Re: APS Professional Development Center (PDC) Parking Deck
3315 Louisiana Blvd., NE
Traffic Circulation Layout
Engineer's/Architect's Stamp **6-24-16** (G18-D048)

Based upon the information provided in your submittal received 6-29-16, the above referenced plan cannot be approved for Building Permit until the following comments are addressed:

C105

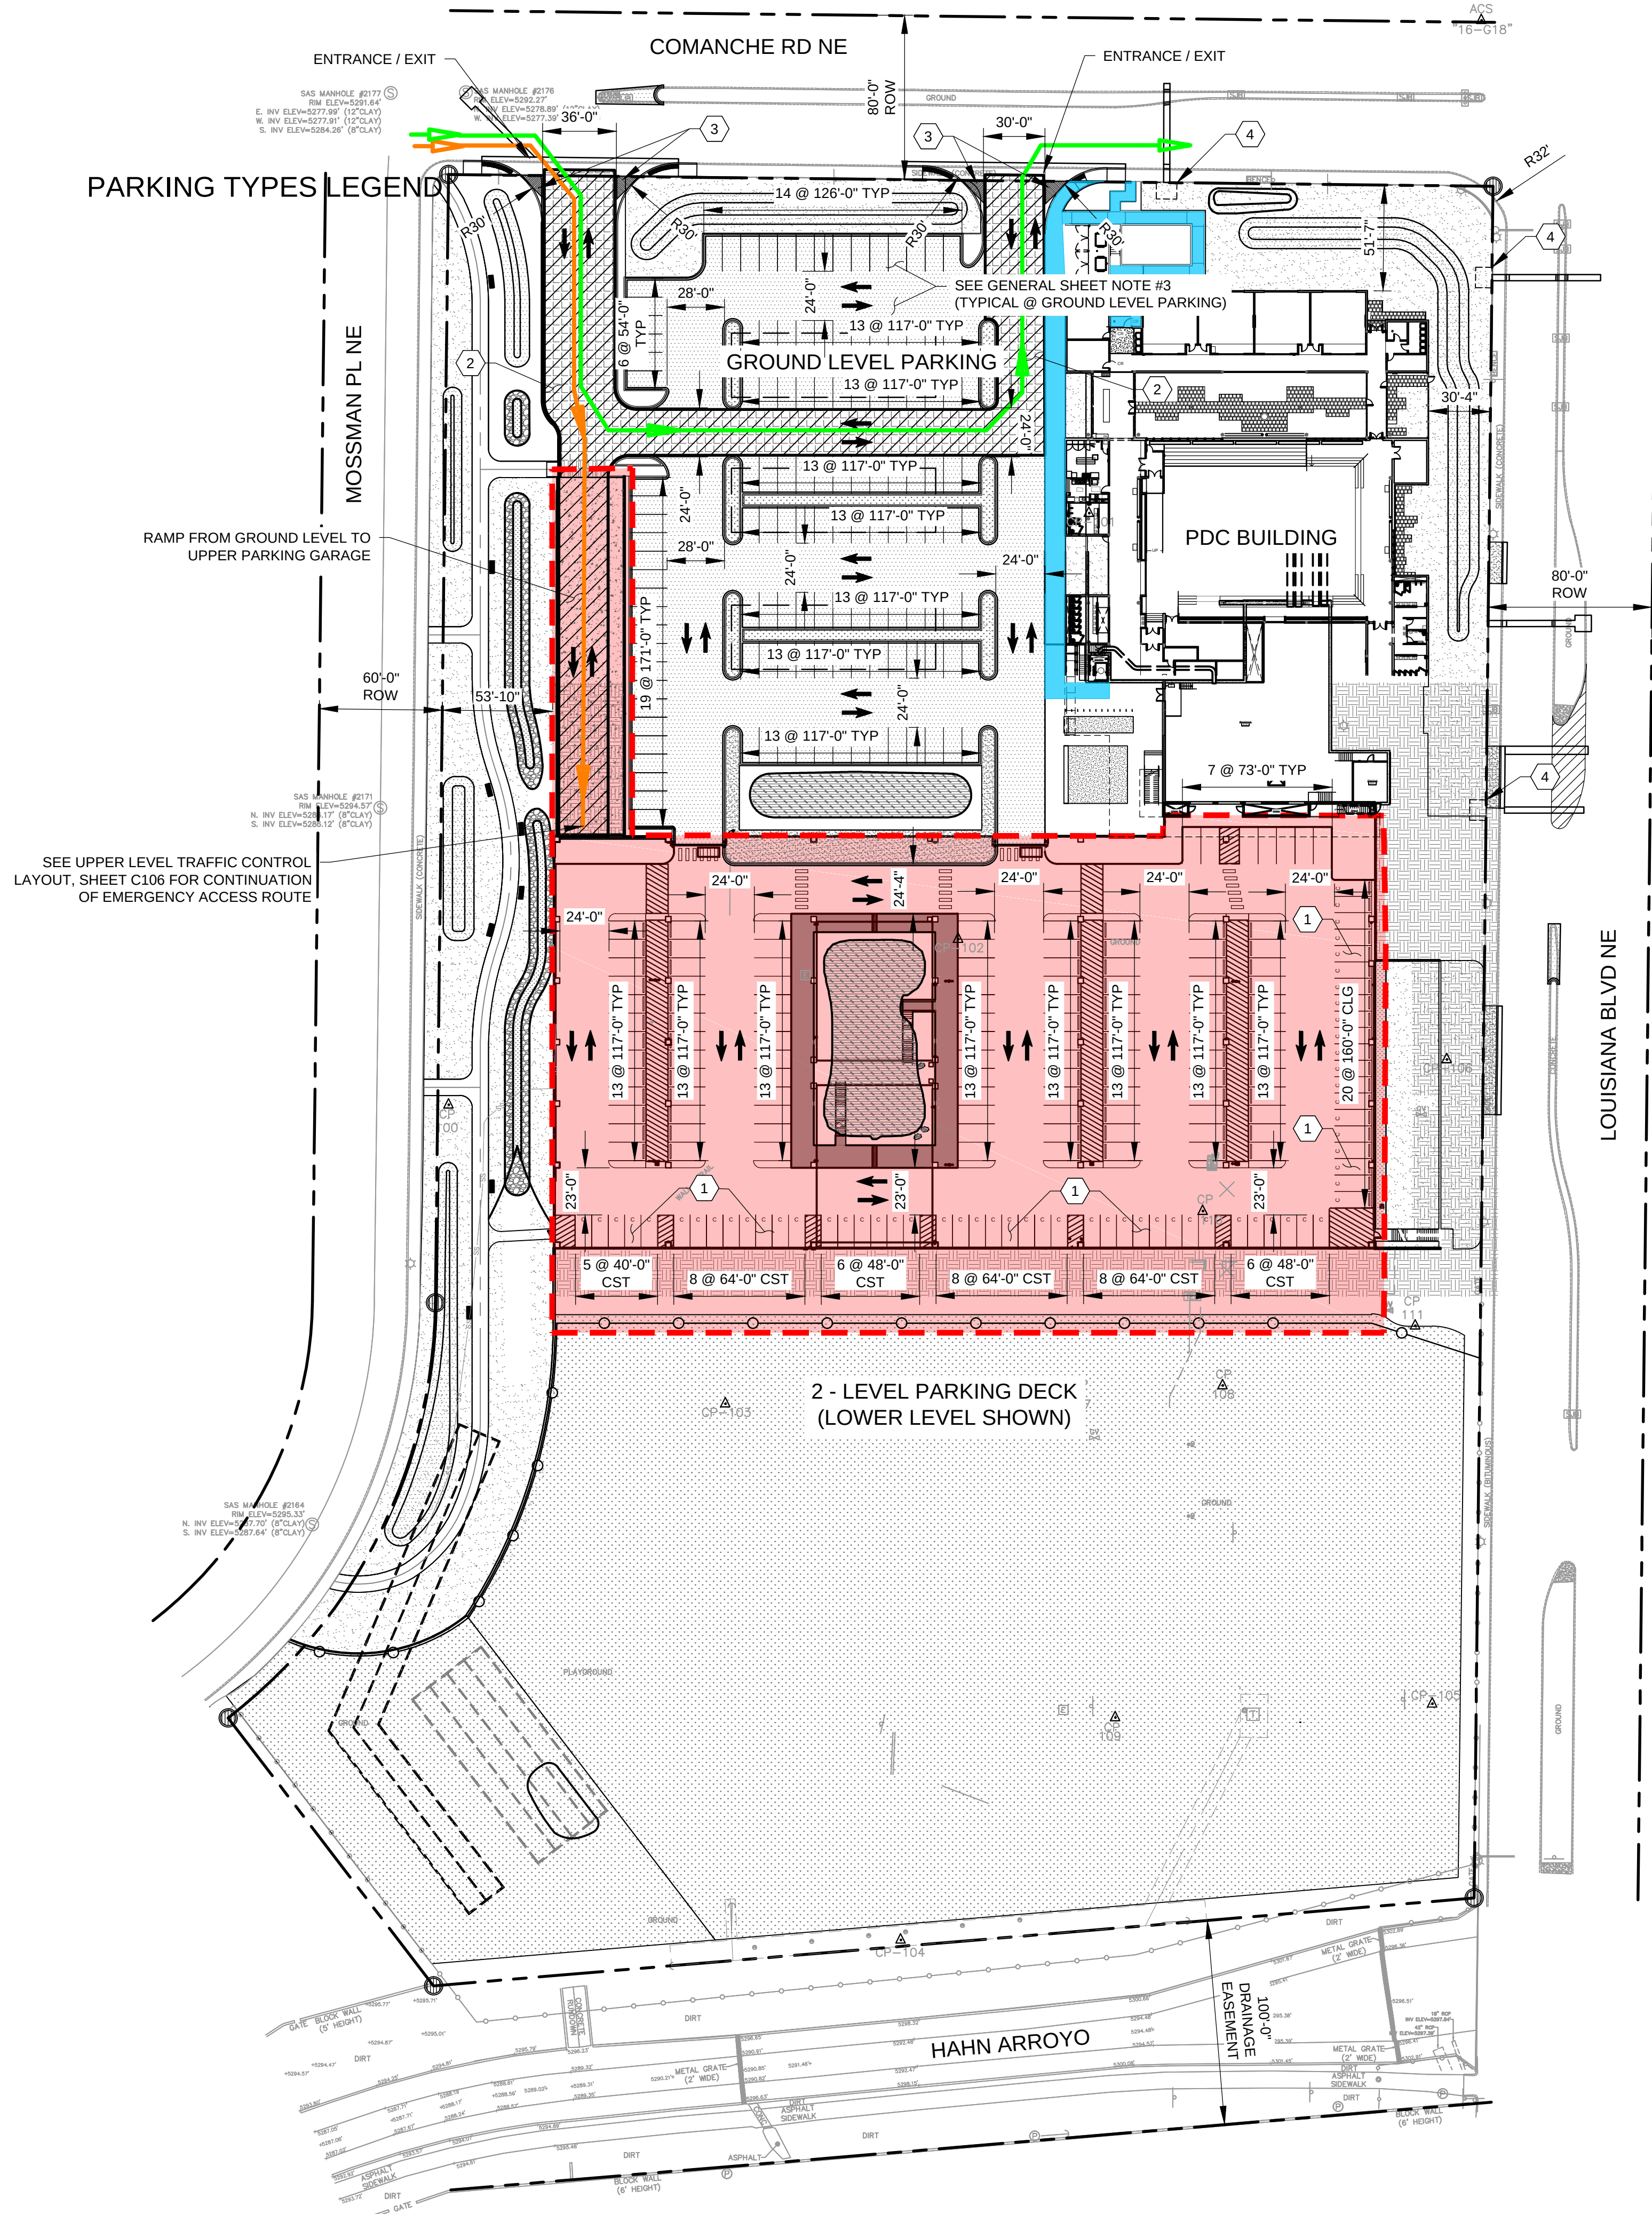
1. List the number of parking spaces required by the zoning code as well as an estimate of the proposed number of parking spaces for future development. Will proposed parking stalls accommodate future development parking requirements?

2. Please identify all existing buildings, doors, structures, sidewalks, curbs, drive pads, wall and anything that influences the parking and circulation on the site.

3. Identify all existing access easements and rights of way width dimensions. Are there easements and ROW dedications at the Hahn Arroyo and Louisiana Blvd. intersection and north east corner of project site at the intersection of Louisiana Blvd. and Comanche Rd?

4. Please list the width and length for all existing and proposed parking spaces.
5. Please verify that the radii fronting arterial streets are within the size per DPM requirements. Provide a Turn Template exhibit for the egress in/out of the project site. Ensure that emergency and solid waste vehicles can enter/exit without encroachment onto opposing lanes.

6. ROW dedication at the north east corner of Louisiana Blvd. and Comanche Rd. will require Plating Action. Please detail HC ramp at this intersection. Any HC ramps serving the public sidewalk must be within the C.O.A. ROW.

7. Median modification and striping on Louisiana Blvd. must be completed via COA Work Order.
8. Please provide side walk obstruction details on Louisiana Blvd.

9. Label the compact parking spaces by placing the words "**COMPACT**" on the pavement of each space.
10. The handicap accessible spaces must be a minimum of 8.5 ft. in width.

11. The handicap accessible spaces must include an 8 ft. wide van access aisle; all other aisles should be 5 ft. in width.
12. The ADA accessible parking sign must have the required language per 66-7-352.4C NMSA 1978 **"Violators Are Subject to a Fine and/or Towing."** Please call out detail and location of HC signs. Please show a detail of signage.

13. The ADA access aisles shall have the words **"NO PARKING"** in capital letters, each of which shall be at least one foot high and at least two inches wide, placed at the rear of the parking space so as to be close to where an adjacent vehicle's rear tire would be placed. (66-1-4.1.B NMSA 1978)

14. Show all drive aisle widths and radii.
15. Per DPM, a 6 ft. wide ADA accessible pedestrian pathway is required from the public sidewalk to the building entrances. Please clearly show this pathway and provide details.

16. Per DPM, a 6 ft. wide ADA accessible pedestrian pathway is required from the HC parking stall access aisles to the building entrances. Please clearly show this pathway and provide details. Please detail location of future HC spaces and ADA access isles.

17. One-way vehicular paths require pavement directional signage and a posted **"Do Not Enter"** sign at the point of egress. Please show detail and location of posted signs.

18. Please provide a sight distance exhibit (see the *Development Process Manual, Chapter 23, Section 3, Part D.5 Intersection Sight Distance*). Please show this detail for the intersection of Mossman Pl. and Comanche Rd. Please also provide a Mini Clear Sight detail for the entrance/exit on Comanche Rd.
